One Earth Solar Farm

Appendix 11.5: LVIA Consultation

February 2025

Document Reference: EN010159/APP/6.21

Drawing file: published-documents / EN010159-000302-6.20 Environmental Statement Volume 3 - Figures 11.9 Local Village Character Areas.pdf

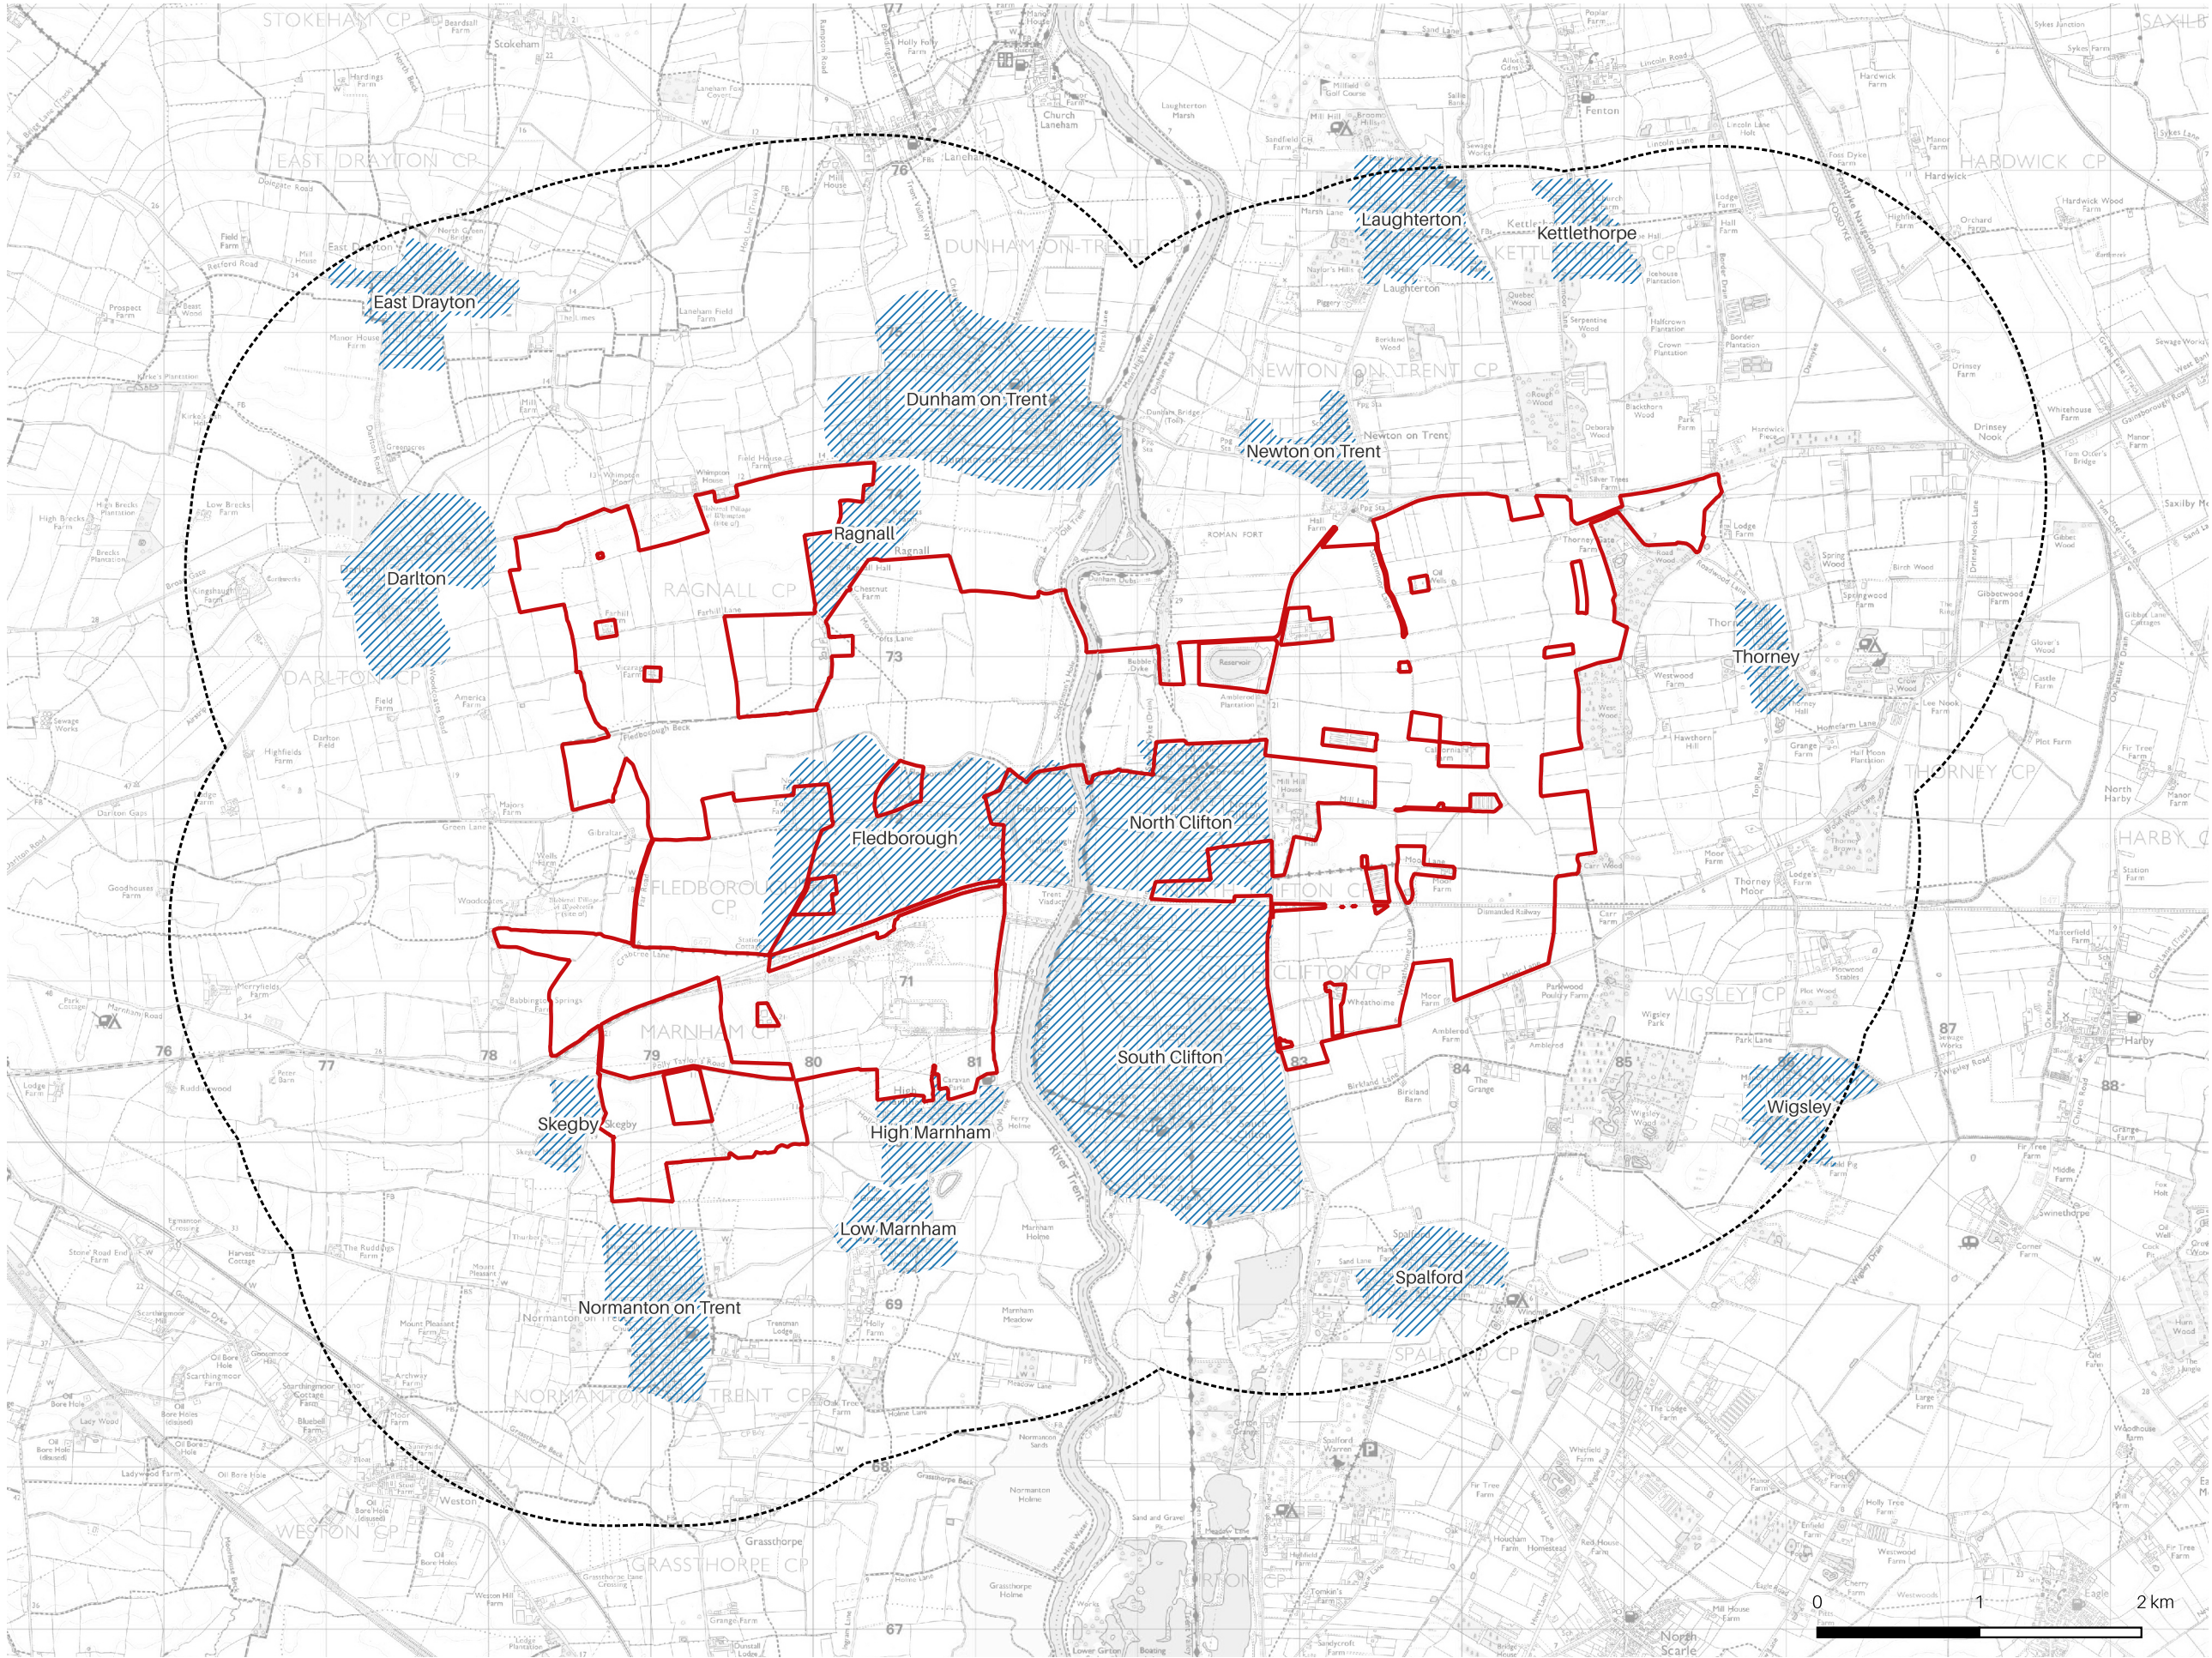
| Item for discussion / agreement | Record of discussion | Action / agreement |
|---|---|---|
| Scale of landscape assessment and approach to landscape sensitivity | Discussion was had around the landscape receptors that would be assessed within the LVIA, and it was welcomed by Via East Midlands that Icen Projects had included Thorney as a Local Village Character Area in response to their feedback on the PEIR. | It was agreed that the scope of the landscape assessment would cover the published landscape character assessments at a regional and local level, as well as site-specific character areas within the study area. |

- Concern about assessing the landscape sensitivity of the published landscape character areas
- Recommendation for additional visual receptor (Thorney) and additional representative viewpoints as follows:

Drawing file: published-documents / EN010159-000303-6.20 Environmental Statement Volume 3 - Figures 11.10 Representative Viewpoint Locations.pdf

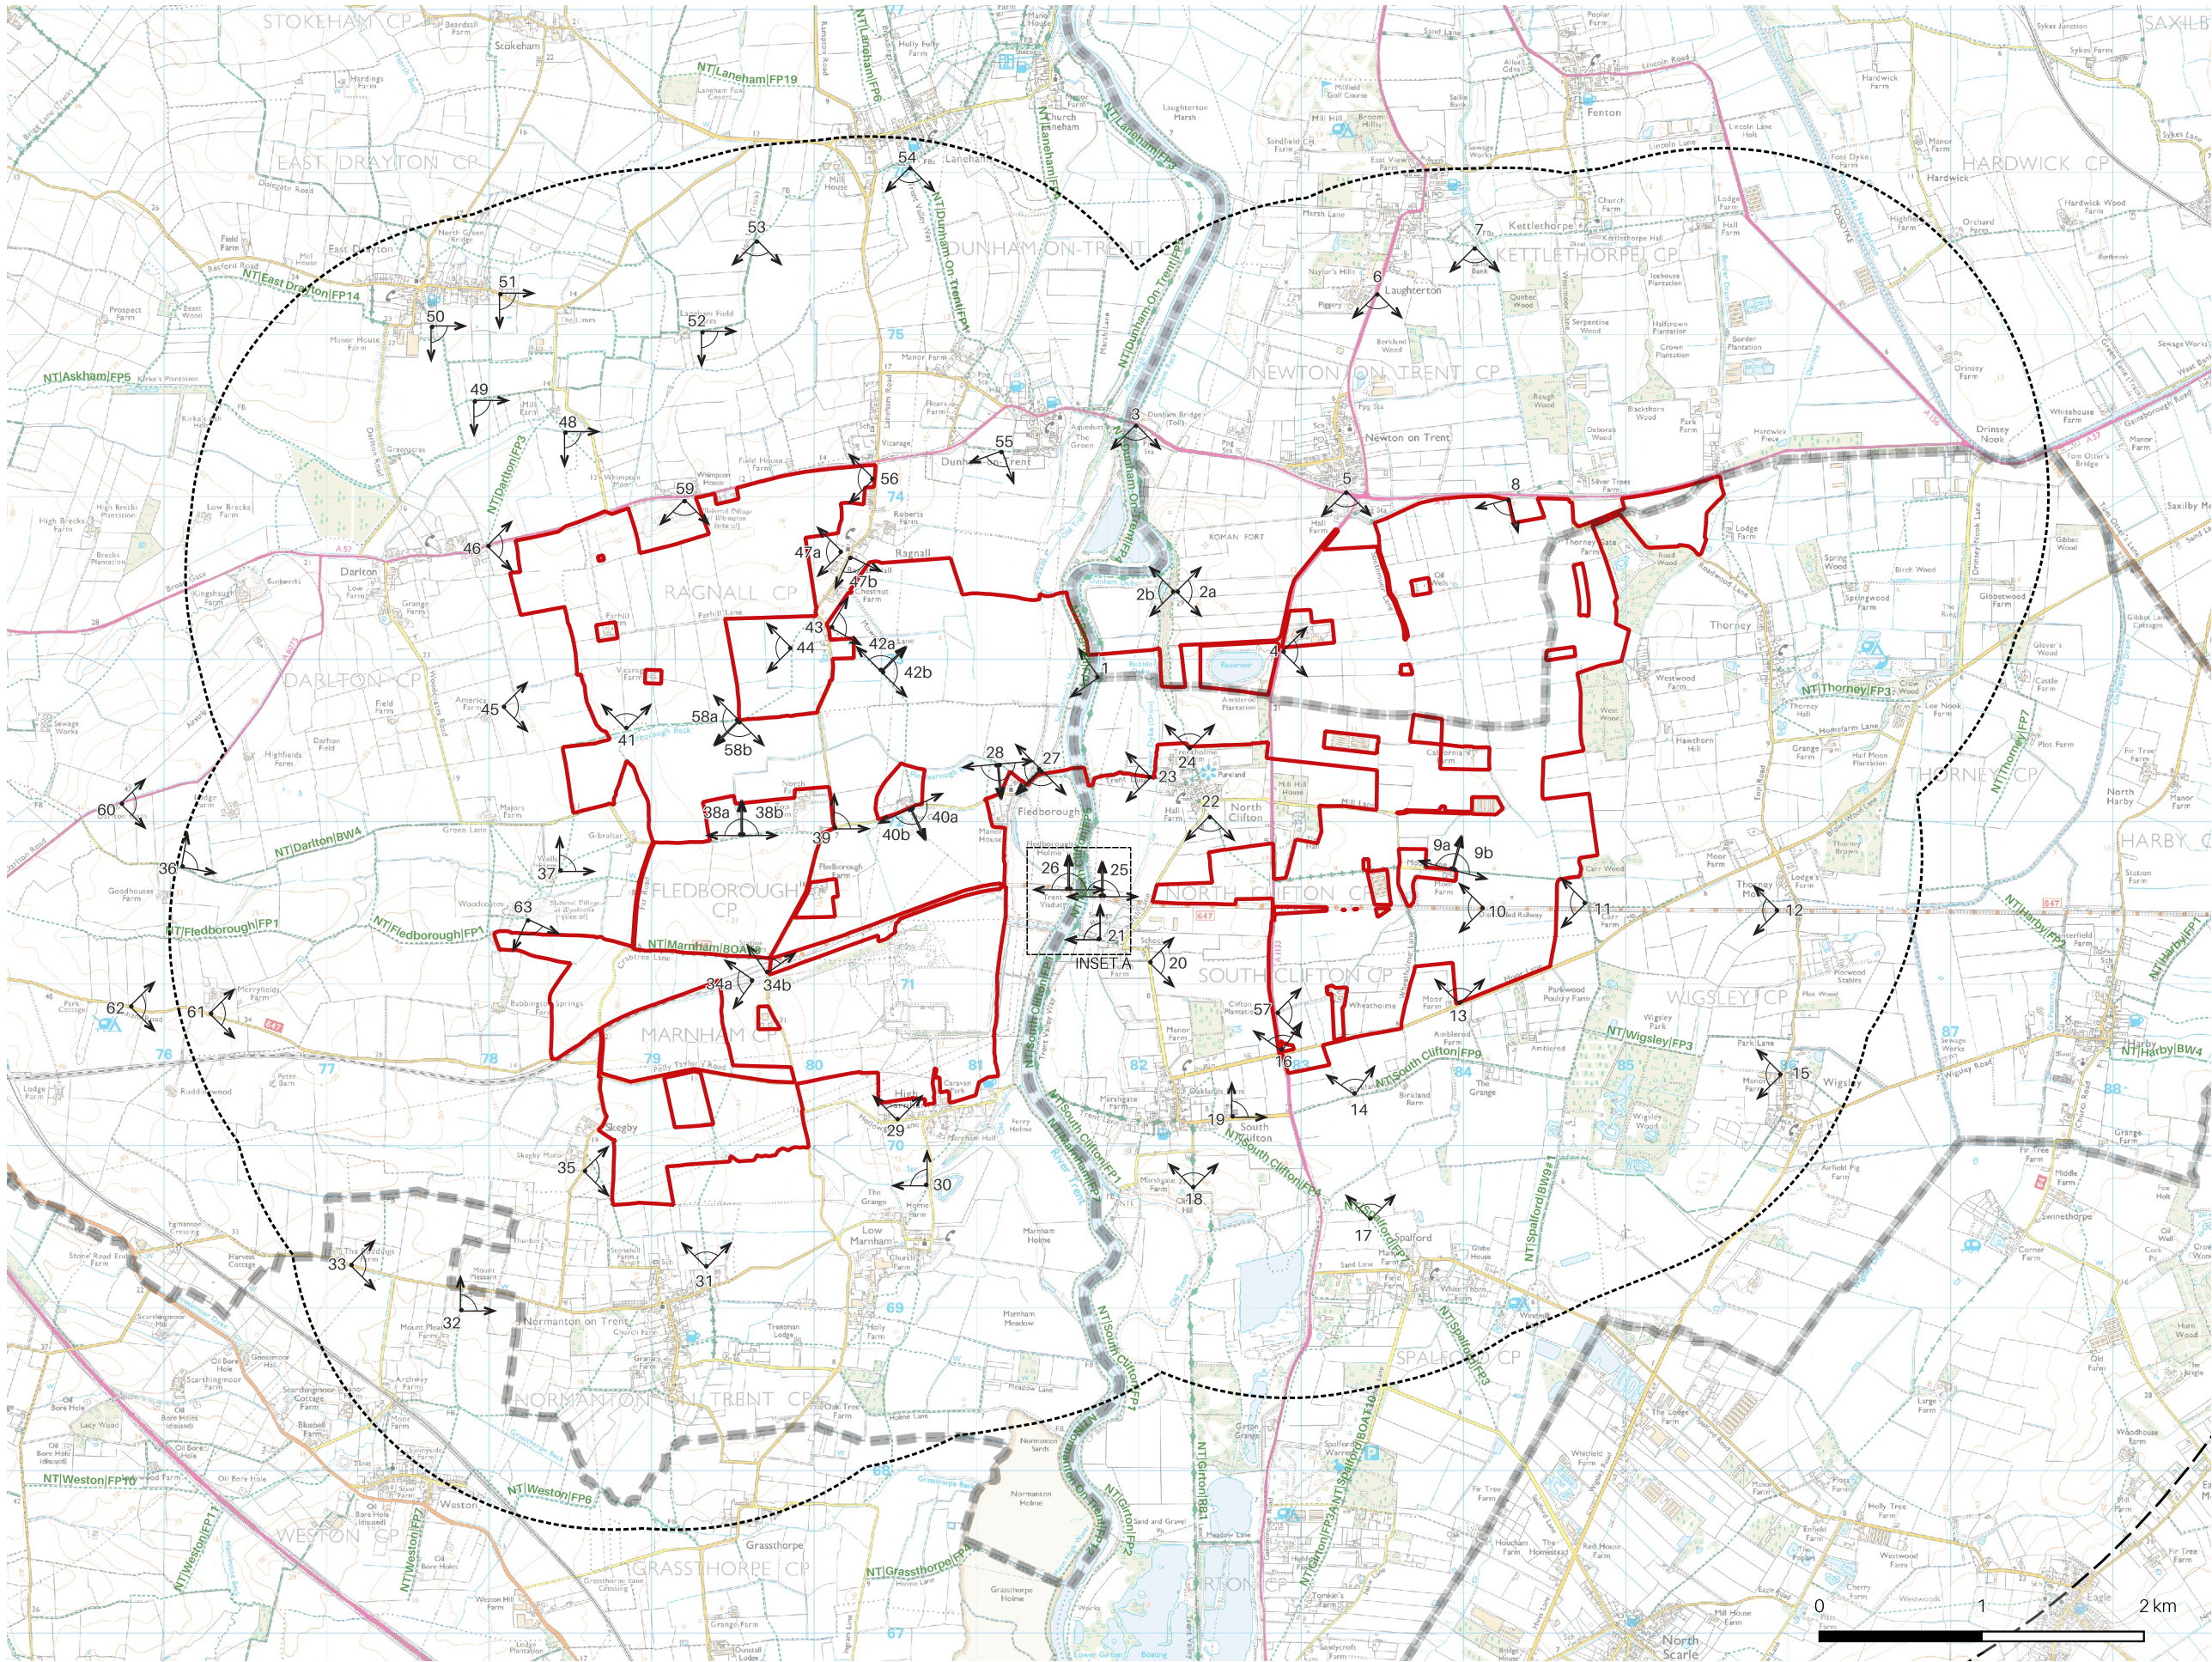
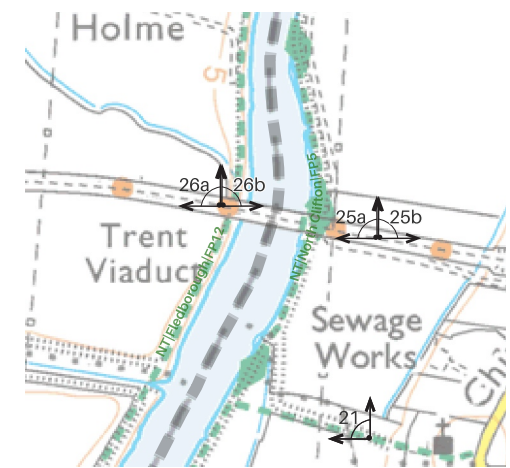
| Item for discussion / agreement | Record of discussion | Action / agreement |
|---|---|---|
| Scope of visual receptors and representative viewpoints | Discussion was had around the additional visual receptors and representative viewpoints suggested by Via East Midlands Ltd at the PEIR stage. This principally focussed on queries on the appropriateness of the location chosen to reflect Via East Midlands Ltd suggestions but also picked up on discrepancies between the photographs and the respective viewpoint plan. | It was agreed that Icen Projects would correct the discrepancies between the LVIA figures. |

- o VP 16 – image is looking west away from the development area which is north and east of this location. Clarify the purpose of this or correct if an error. If correcting VP will need to move north along A1133.

- o VP 25 & 26 – Photographs taken with parapet railings dominating the horizontal line of sight, as such detracting for the wider extent of the landscape, and therefore preventing clear sight of the development in the visualisations shown in the consultation booklet. Photographs should be retaken closer to the parapet to allow clear line of sight of the surrounding landscape. Images also do not show extent of development site. This should be marked on the updated images.

- o VP 26 – Location marked up incorrectly on the viewpoint map as this should be west of the River Trent.

- VP27 – View stated as looking south and south west which would be away from the development, (more west & north west at this location). Clarify the purpose of this or correct if an error.
- VP28 – View stated as looking south and east from Fledborough footpath 10 away from the development. Impact from the development is more immediate to the north and west of this location. Clarify the purpose of this or correct if an error.
- VP46 - View direction should read view east along A57, not A1133. Correct.
- Recommendation for the viewpoint imagery and viewpoint assessment to be completely reviewed and updated to ensure information presented is accurate and representative showing both areas where potential views are discounted and areas where views are significantly impacted.
- Suggestion to provide more details of cumulative schemes with reference to landscape character areas.

- Specific comments regarding representative viewpoint locations, including:
 - Viewpoint 12, along the Sustrans route, needs to be reconsidered as it is located within woodland and the merit of the view is therefore diminished.

- Likewise, viewpoint 18, which is from footpath 153/3/1 is dominated by a hedgerow in the foreground, and we would suggest a more carefully selected view, which captures the same receptor experience but provides a wider context than an enclosed route due to the hedgerows. An alternative view could be from South Clifton looking south.

- Viewpoint 19 is not well sited, and alternatives around the settlement of South Clifton should be considered. The view here is blocked by the residential property and a wider context view from the edge of the settlement would be more appropriate.

- Specific comments regarding representative viewpoints, including:
 - o Viewpoints 1 & 2 are good wide views and show the site in a wide context. Likewise 3 & 4 seek to achieve the same output, however the tree belt in 3 and the railway bridge in 4 detract from the view. This reinforces the comments above where fine grain view selection is needed. The value of 3 & 4 is significantly less than 1 & 2.

- o Viewpoint 5 is of little benefit, again we request that this view is moved to provide a more useful impression of the impact on the residential properties.

- o Viewpoint 6 is in a useful locality, but given the tree belt, the view itself has limited merit. It would be beneficial to find a view in the locality that corresponds to a break in the trees and provides a more useful context to the site and the residential properties.
